Bicester Gateway Phase 1b RMA

Response to OCC Comments on Application

Project: 226701

By: FC / Date: 22/09/22

DRAWING NUMBER: **226701_PD01** REVISION: .

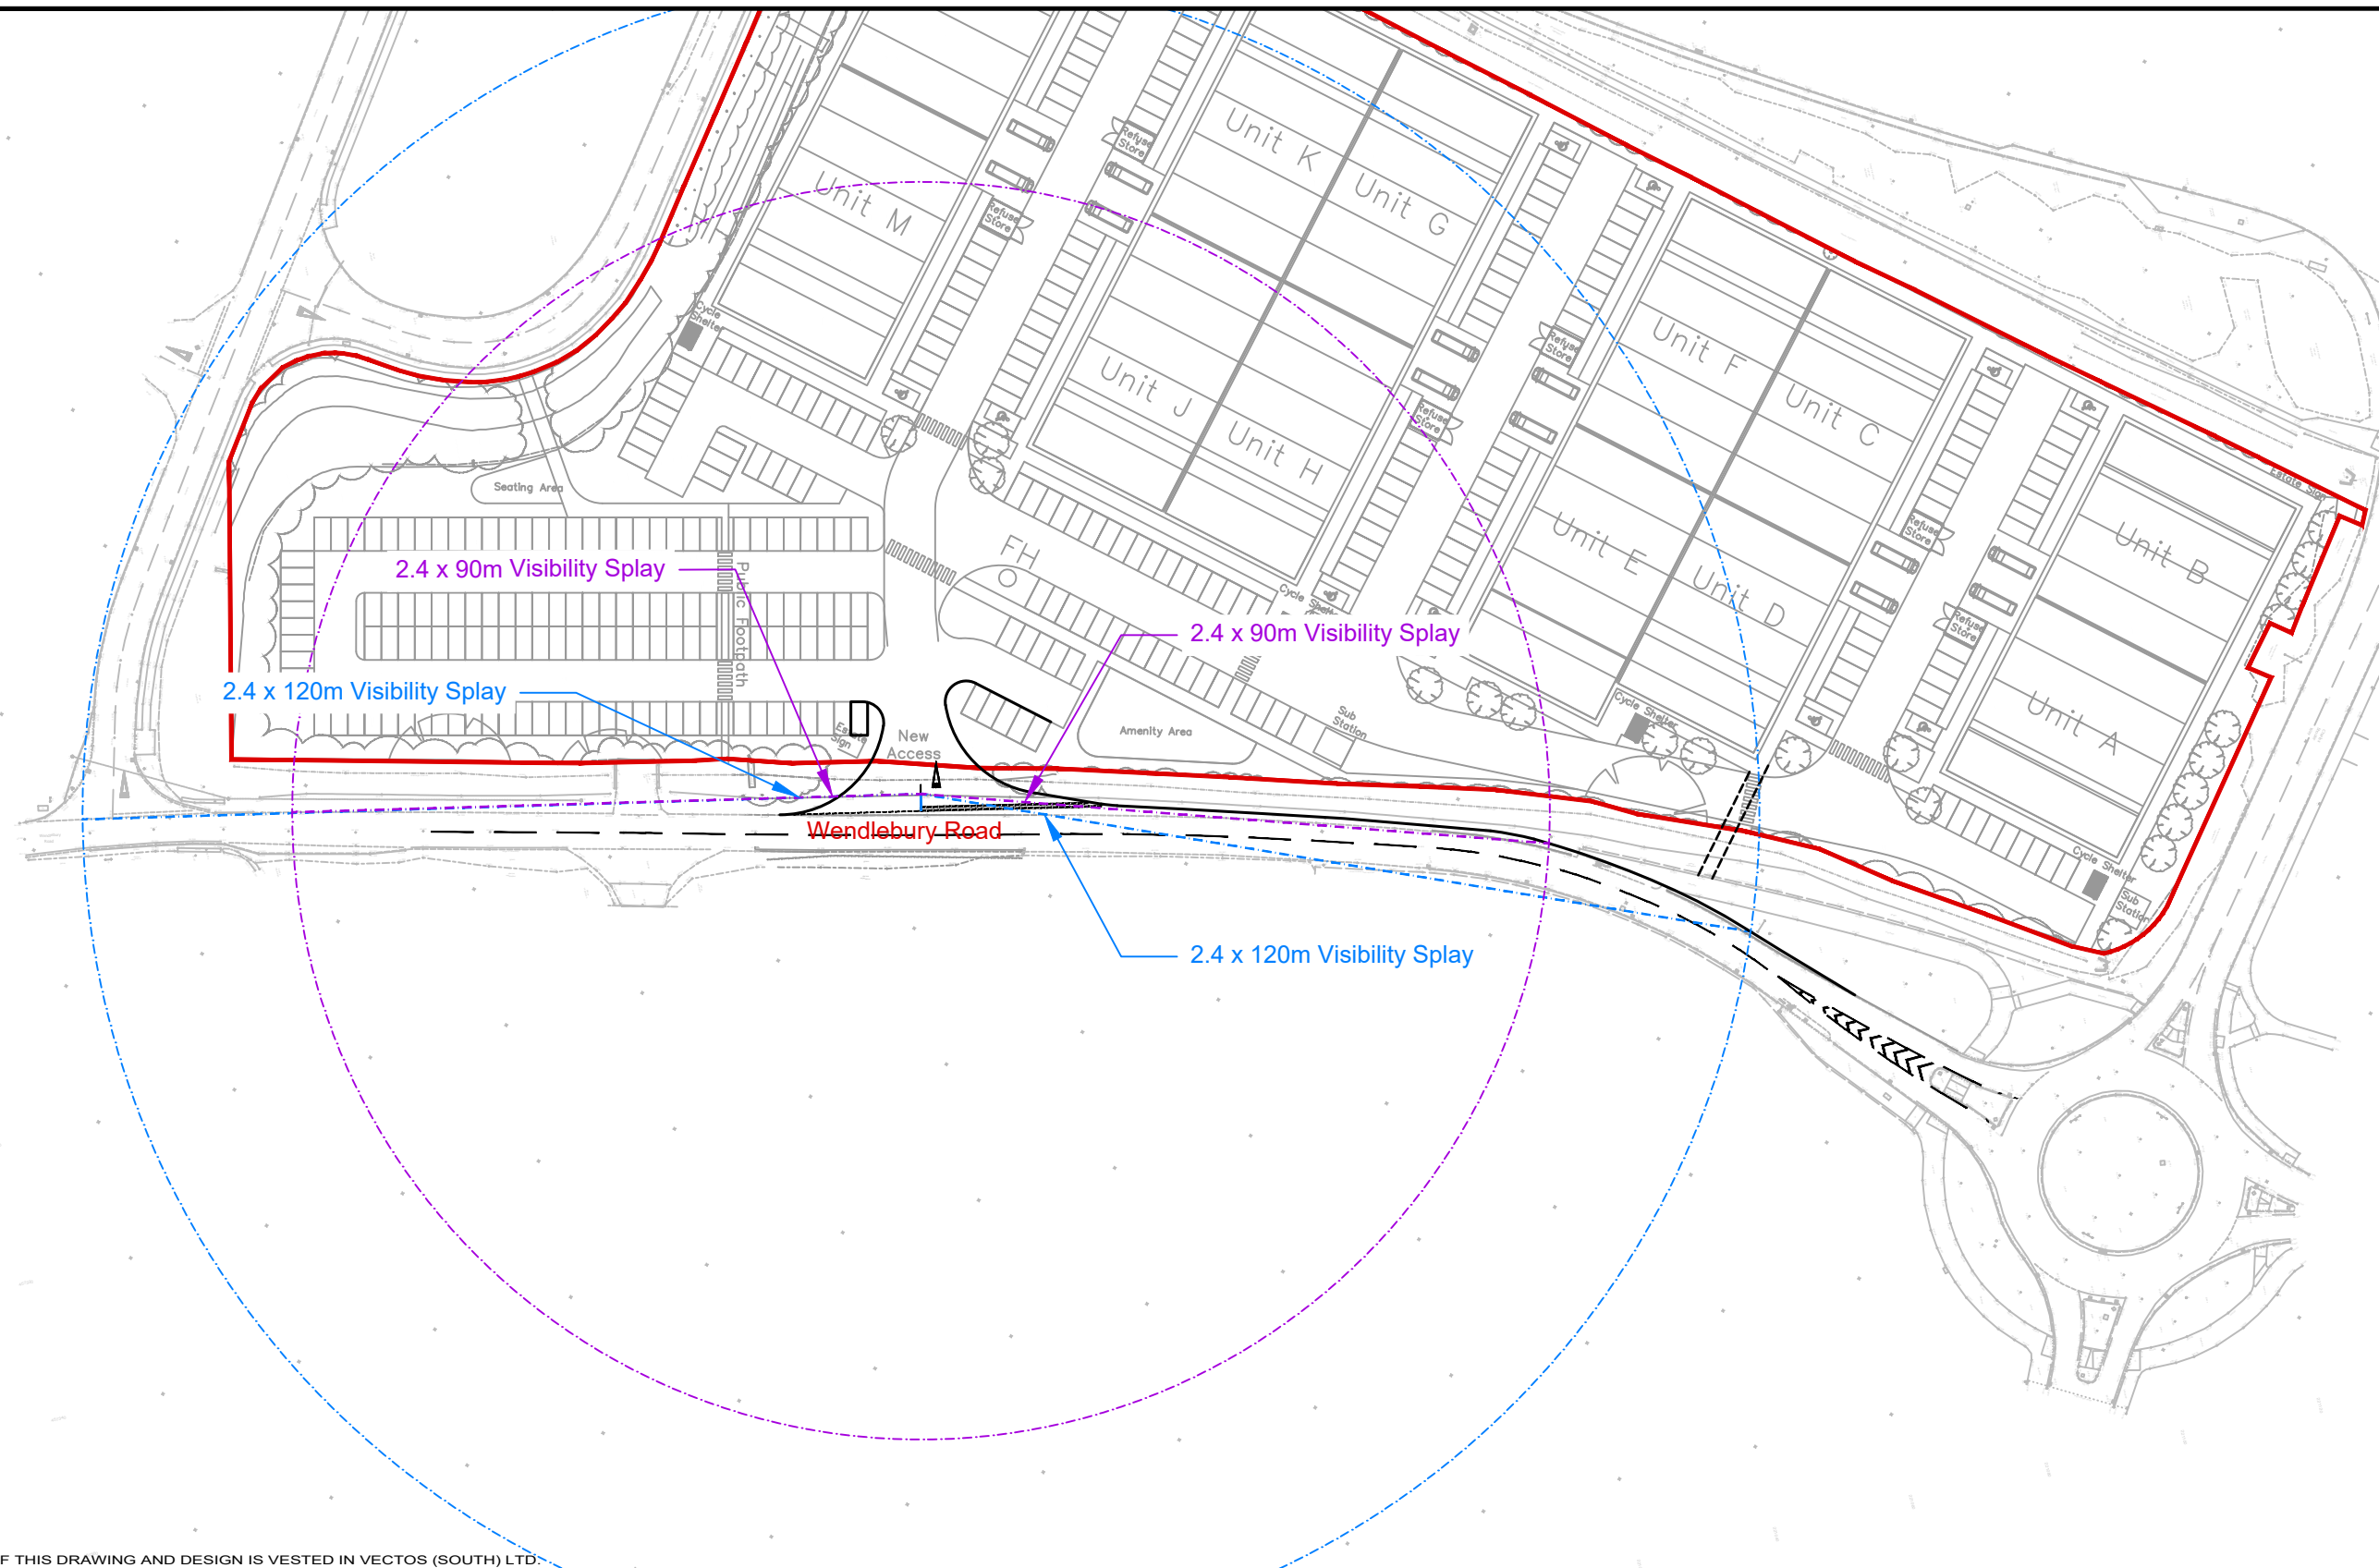
The cycleway should be extended out past their bellmouth to get cycles off carriageway sooner and have their bellmouth as a set back cycle crossing in line with LTN1/20.

27. These new requirements suggested by OCC are directly contradicting the access parameters for the Bicester Gateway Phase 1b site agreed at the time of the outline consent and that the Reserved Matters Application adheres to. The agreed access provision of the Bicester Gateway Phase 1b site is to deliver an improved 3m wide shared footway/cycleway along the site's A41 frontage. This facility is to connect with the disused slip road between the A41 and Wendlebury Rd to the southwest of the site, delivering an off-carriageway connection between Wendlebury Rd South and the A41. The proposed new shared footway/cycleway would also be consistent with the existing facilities along the A41 into Bicester, and in particular the section of footway/cycleway delivered recently by the Bicester Gateway Phase 1a site, in line with the outline consent. There can be no reasonable case to divert from the A41 focus agreed at outline stage, especially given the works already implemented for Phase 1a.

28. Reference is made to LTN120. Although LTN1/20 promotes a new approach to designing for cyclists and states a preference for segregation from motorised vehicles and also from pedestrians, it does not preclude the delivery of shared footways/cycleways especially along radial and interurban routes such as the A41 and where continuity of a route can be delivered (here between Wendlebury Rd South to the existing facilities along the A41 into Bicester). Therefore, the agreed shared footway/cycleway along the A41 frontage to the site forms a suitable improvement to the local cycling network.

29. The improved footway/cycleway to be delivered as part of the Bicester Gateway Phase 1b development and in accordance with the scheme agreed at outline would deliver a route for cyclists between Wendlebury Rd South and Bicester to the north, taking cyclists away from Wendlebury Rd and therefore away from the Phase 1b site access, rendering the requirement set by OCC in their response unnecessary (whilst also outside the scope set by the approved outline).
